Planning Application Reference: 6/2017/1079/FULL  
Proposed development at: 37 Lambs Close, Cuffley, Potters  
Bar, Hertfordshire EN6 4HD  
The erection of x3 two-bedroom flats and provision of x3 car parking  
spaces

I am writing to object to planning application 6/2017/1079/FULL on the ground of insufficient off-street car parking spaces.

5 Proposed Site Plan - Roof Plan
1:200

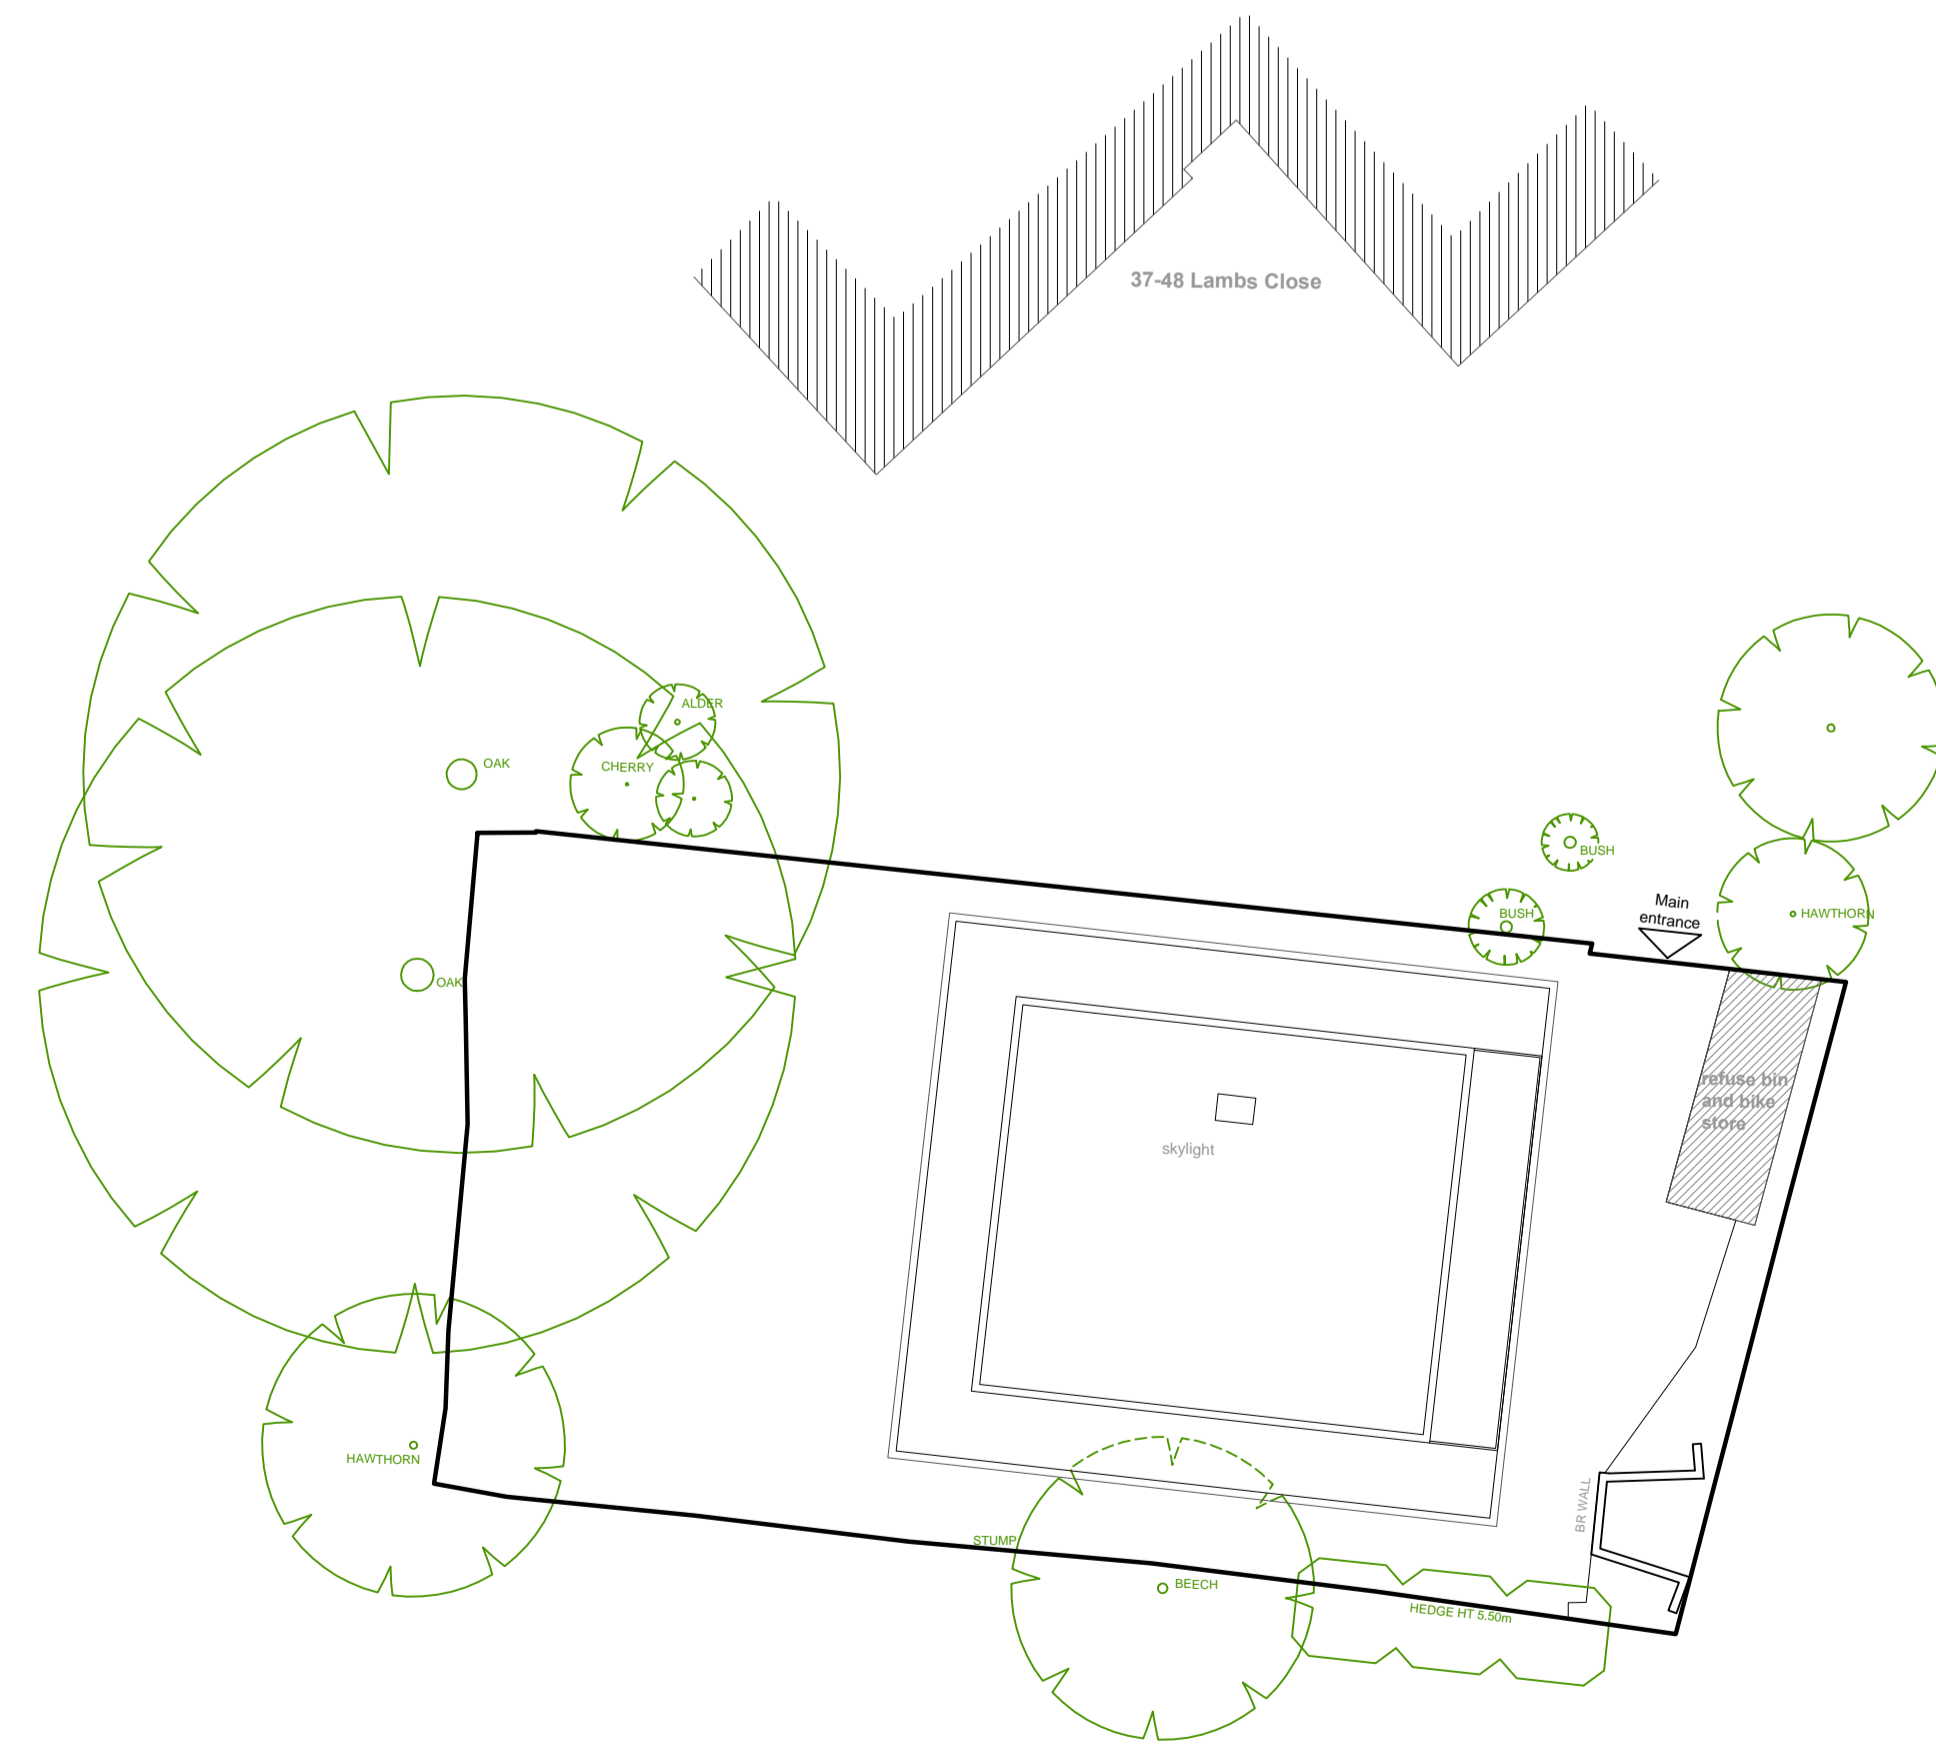
There are already not enough off-street or on-street car parking spaces for residents of the existing four blocks of flats. Planning application 6/2017/1079/FULL proposes only one off-street car parking space per two bedroom flat. This will inevitably cause overspill car parking along Lambs Close, exacerbating the aforementioned car parking problem.
